GRANDVIEW RESERVE  
 METROPOLITAN DISTRICT  
 ROAD AND TRAFFIC

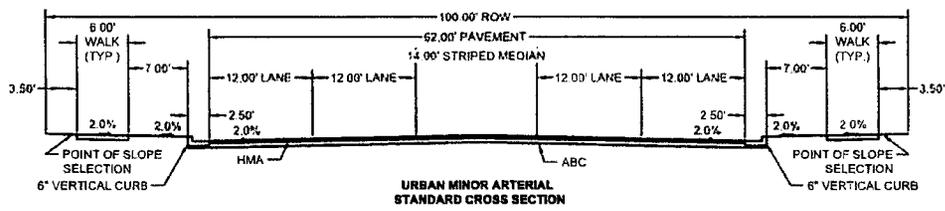
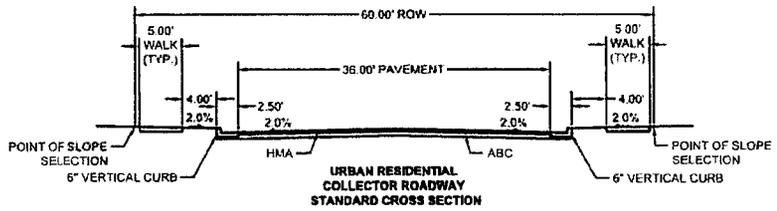
1.	Comment from PCD – Engineering: Proposed total mill levy is incorrect.	Revised
2.	Comment from PCD – Engineering: On the Road and Traffic Plan Sheet 3, the description titled as “URBAN RESIDENTIAL ROADWAYS” should be “URBAN RESIDENTIAL COLLECTOR ROADWAYS.”	Revised
	County – Service Plan	Response
